MORGAN AND MORECAMBE OFFSHORE WIND FARMS: TRANSMISSION ASSETS

Technical Note: Landscape and Design Matters

Deadline: Deadline 3
7 July 2025

Document reference: S_D3_7

**Figure 1.8: Outline management of PRow within the Onshore Order Limits (Sheet 5)**

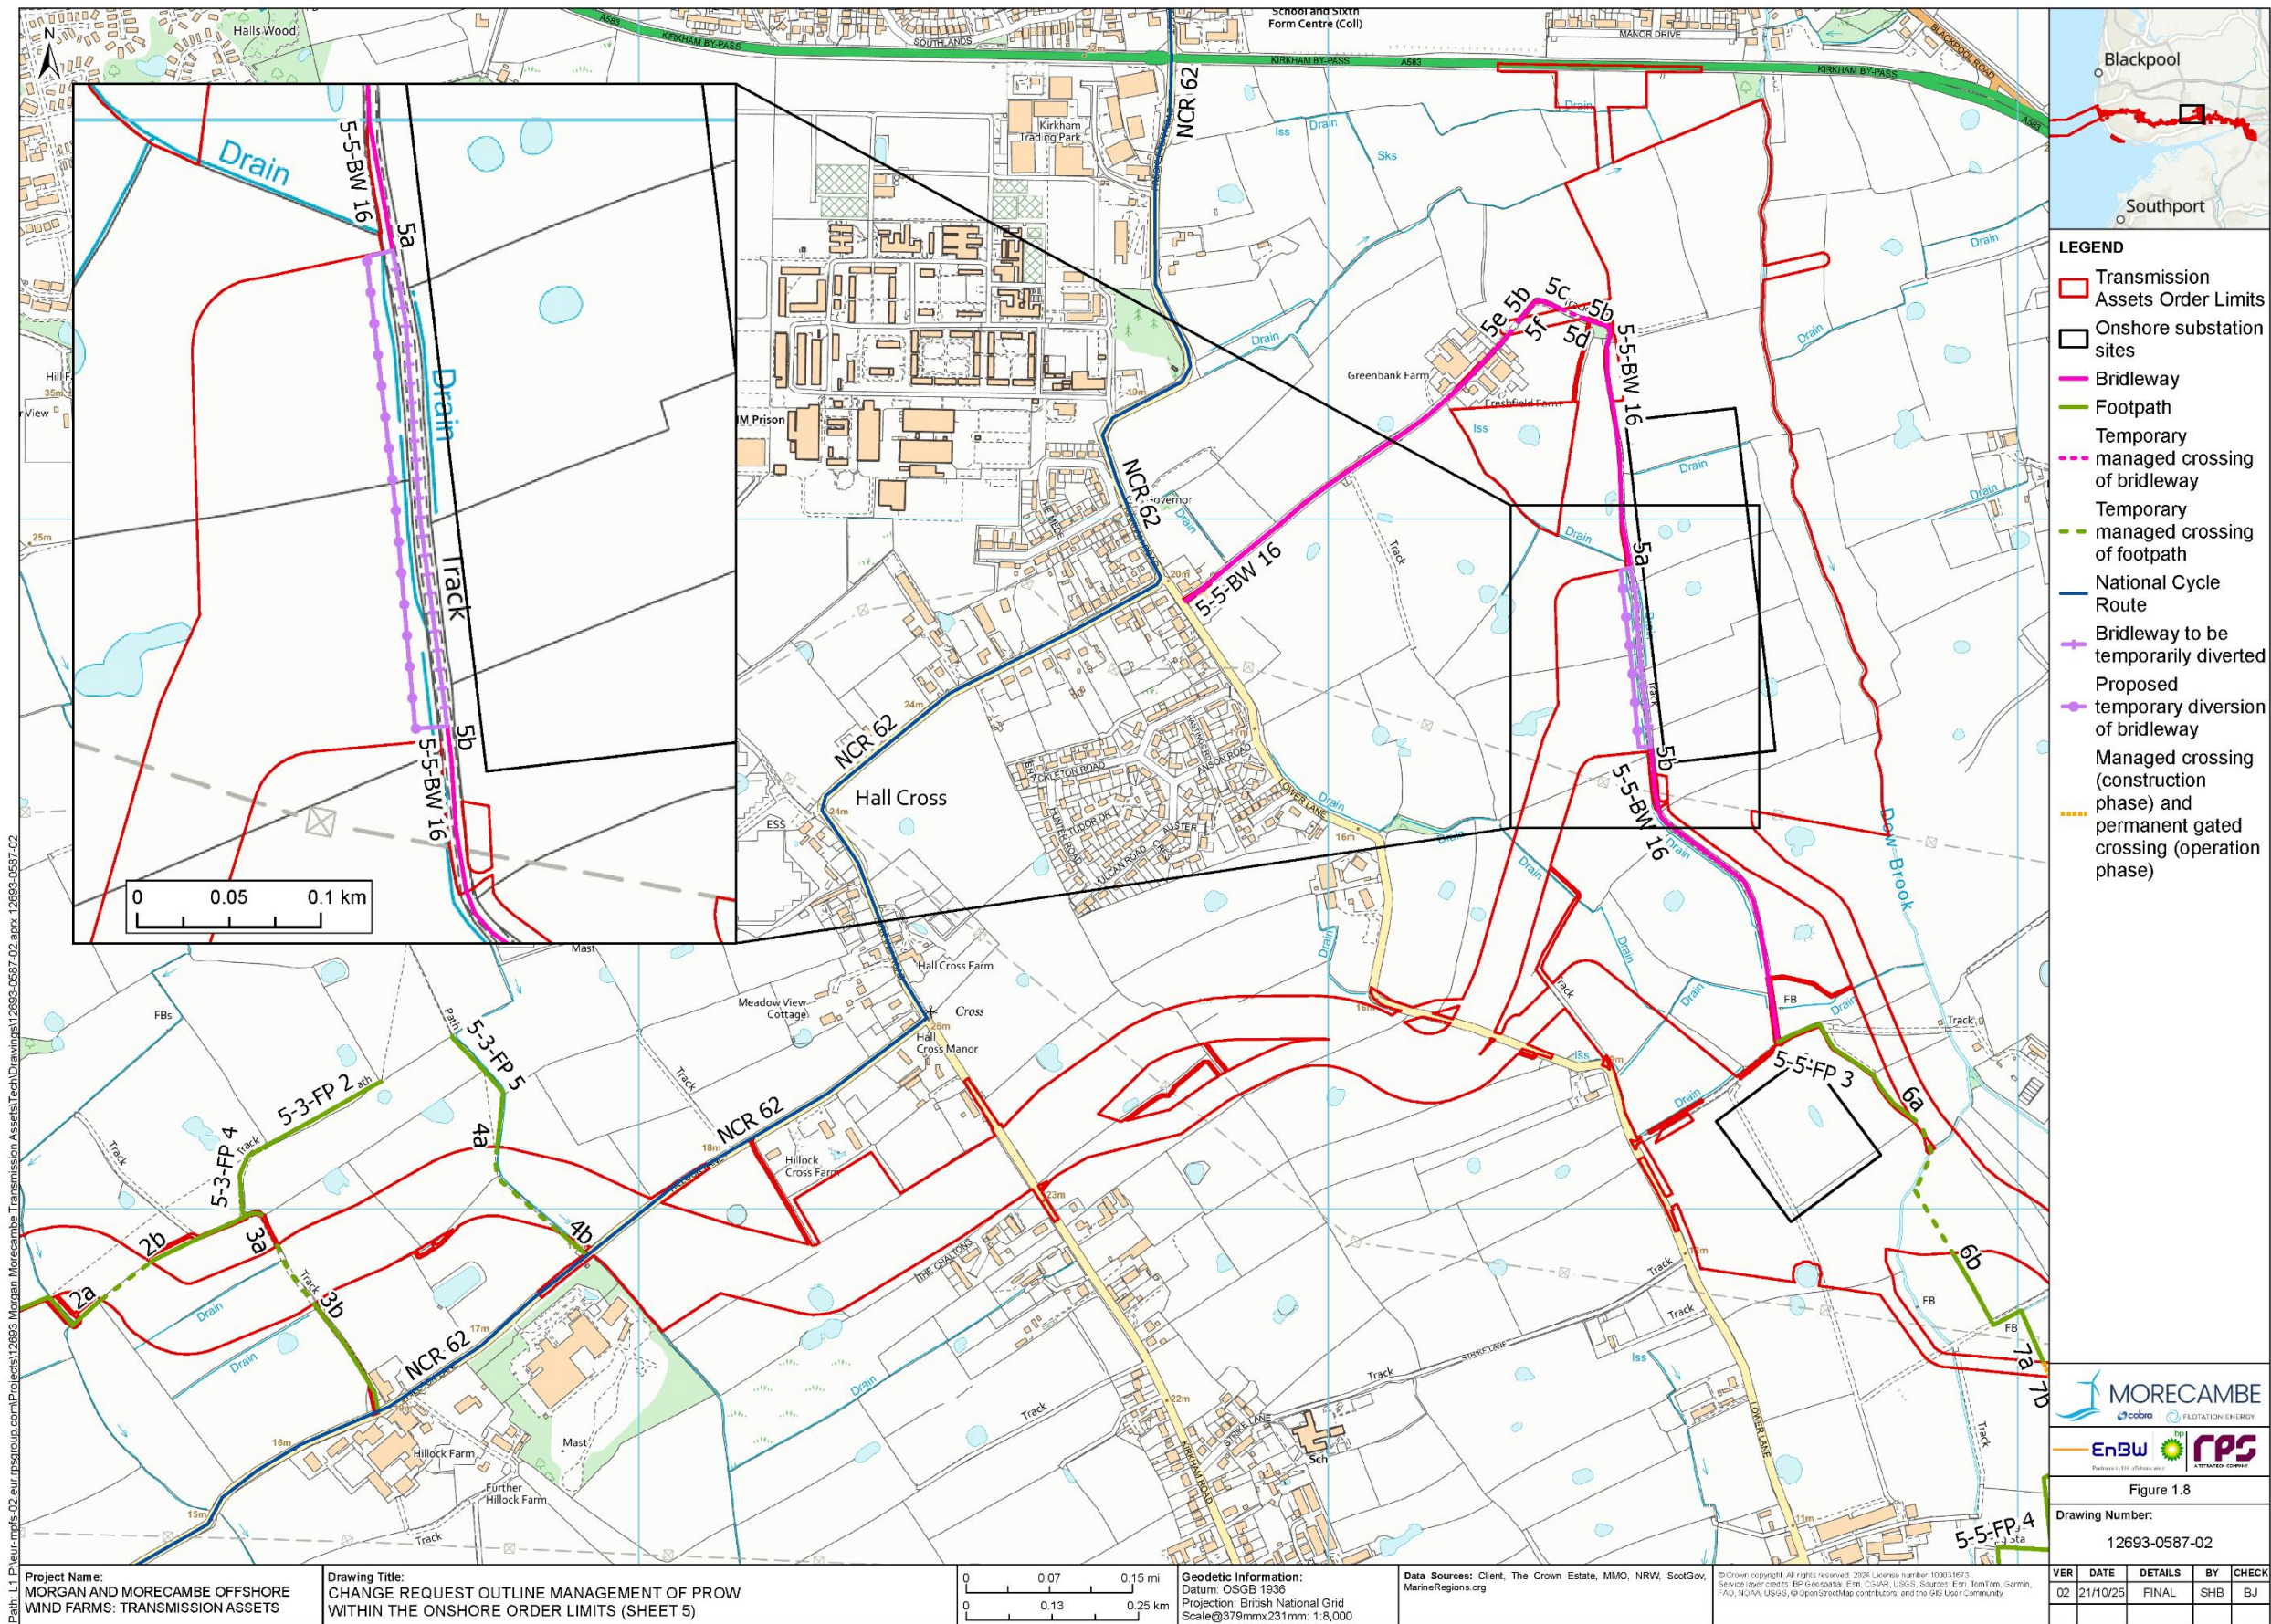
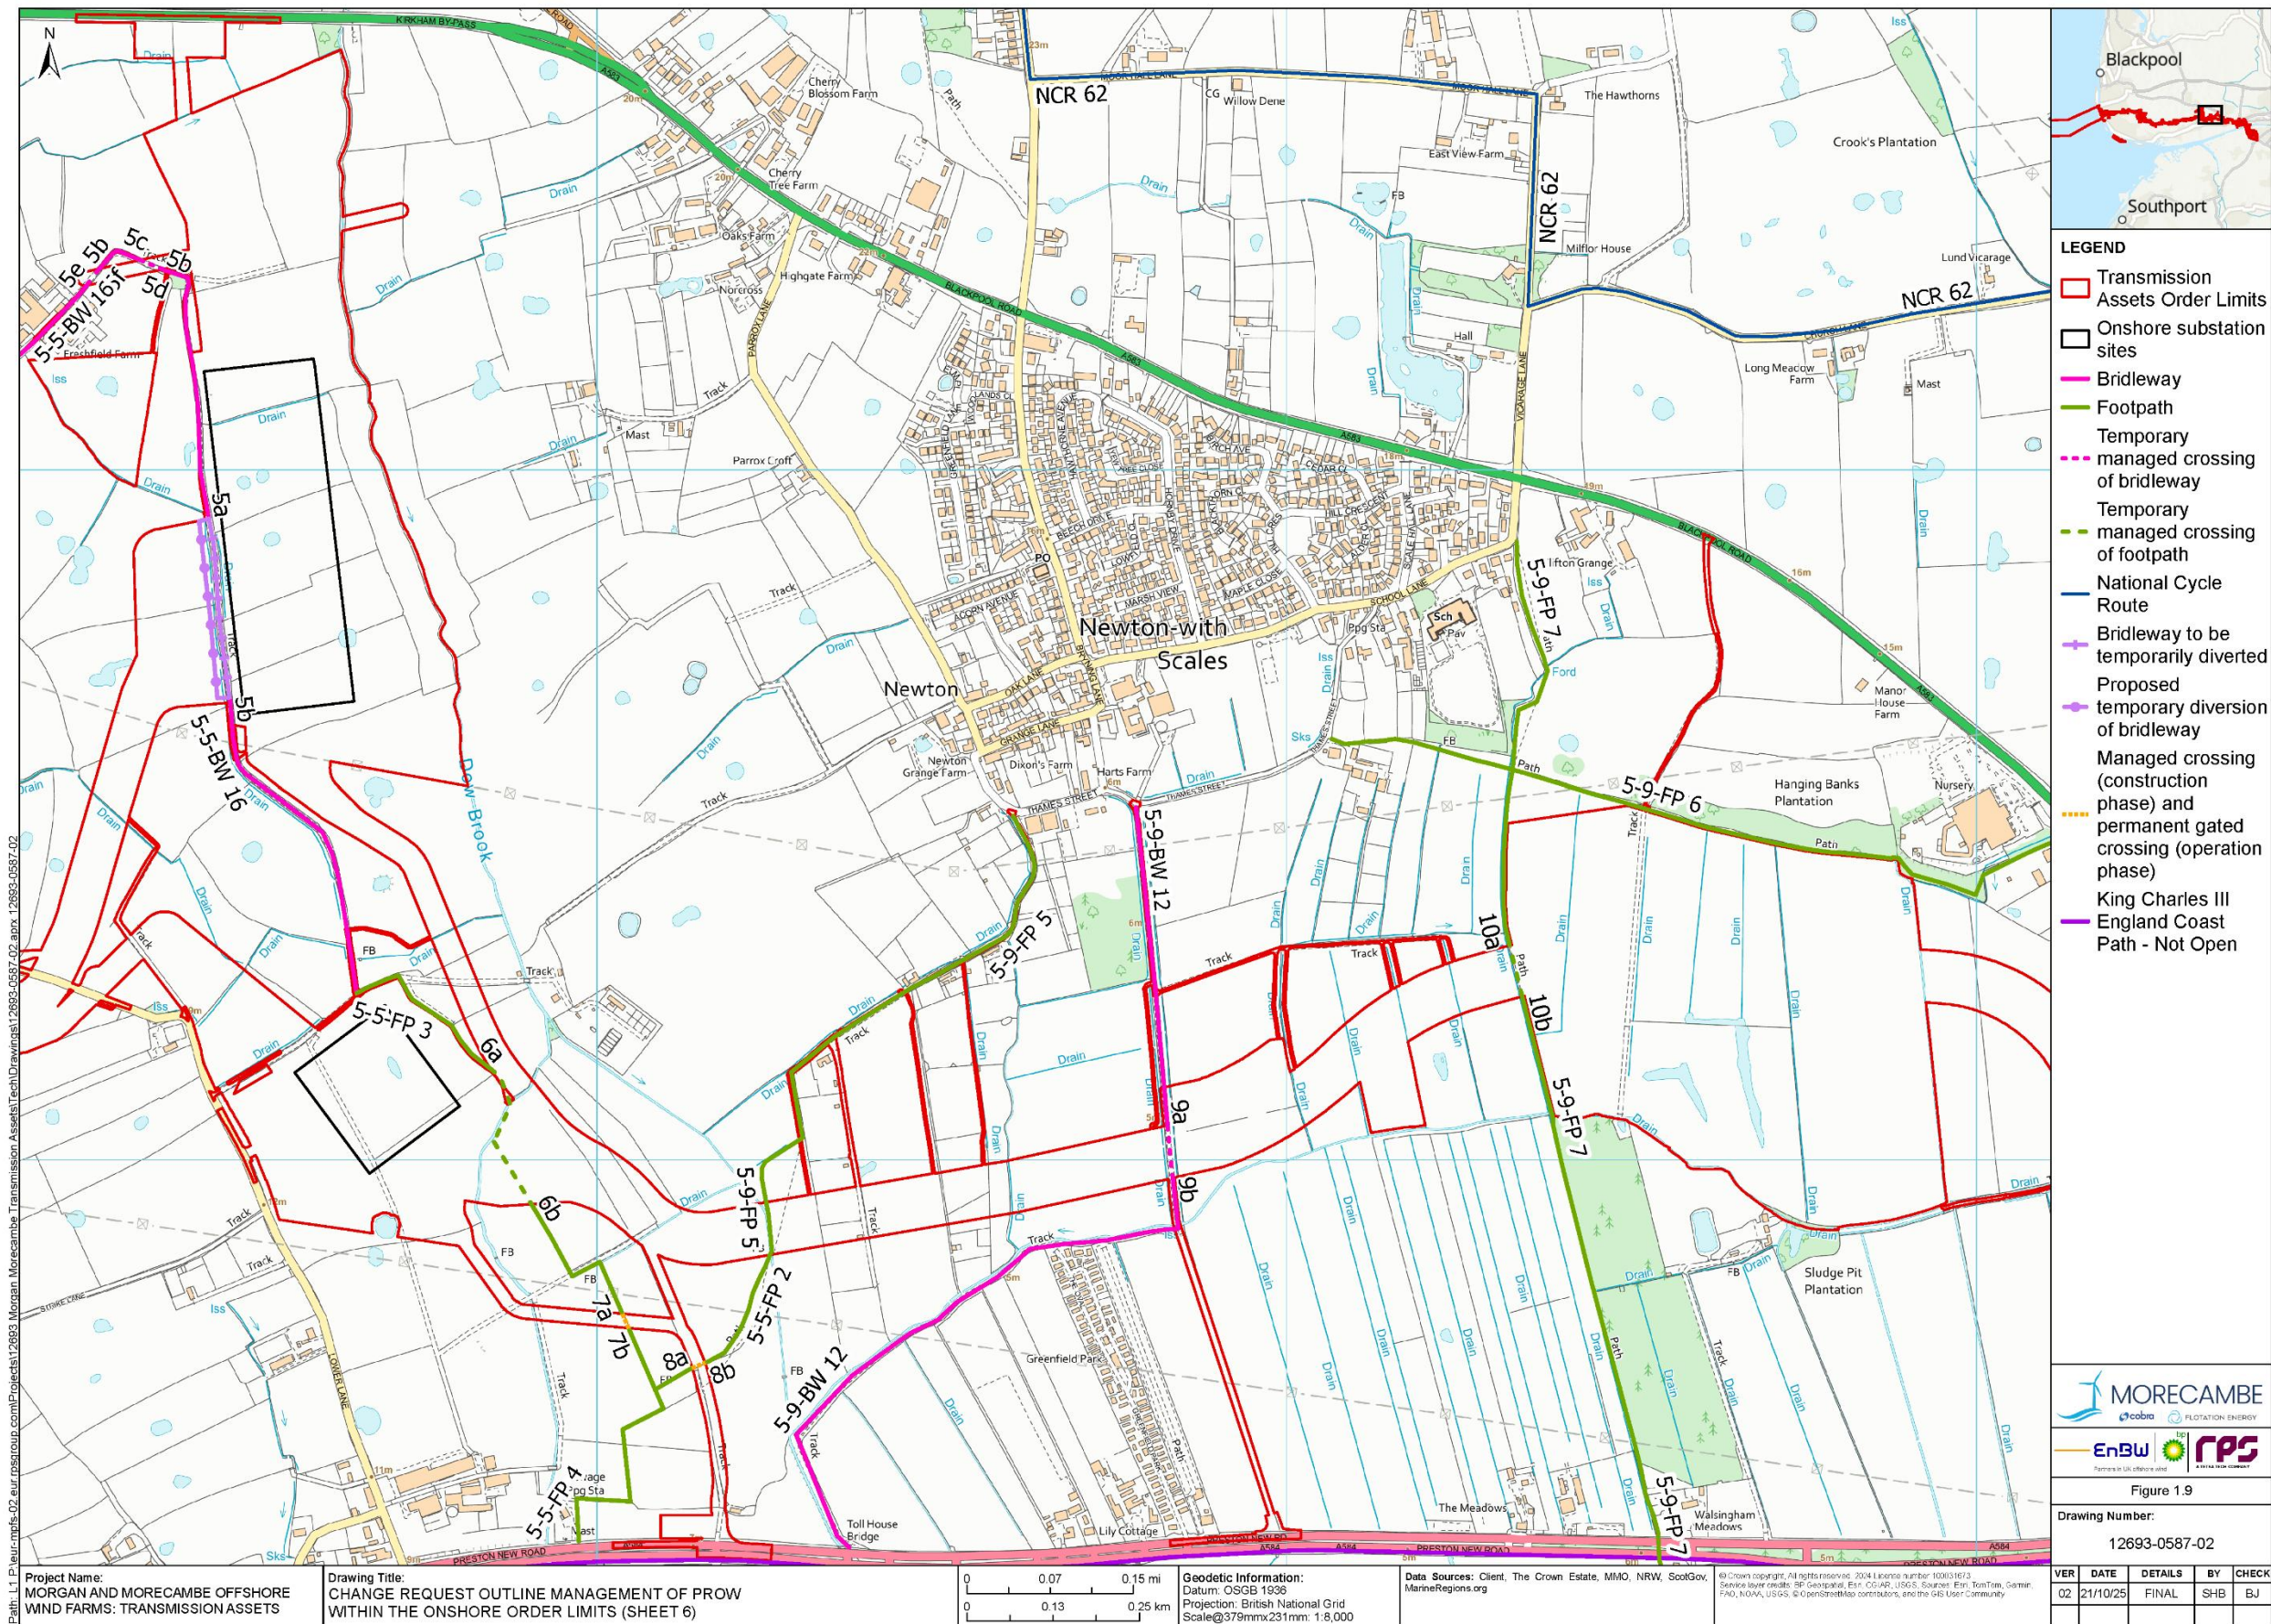
- 1.2.1.1 LCC LIR comment **REP1-085 7.49** raises concerns about the lack of detail in relation to the reinstatement of Public Rights of Way (PRoW) affected by the transmission works, particularly in relation to surfacing materials and demarcation, and requests clarity on how these will be restored, including features such as gates and signage.

- 1.2.1.2 The Applicants refer to the Outline Public Rights of Way Management Plan (AS-048), secured through Requirement 8 of the draft DCO (REP2-004) (dDCO). This Requirement outlines the principles for managing PRoWs during construction, making clear that detailed PRoW Management Plans will be developed and approved by relevant planning authorities, in consultation with stakeholders, before works commence. These plans will include specific information on surfacing and design, as confirmed in Section 1.5.8 of the Outline Public Rights of Way Management Plan (AS-048).
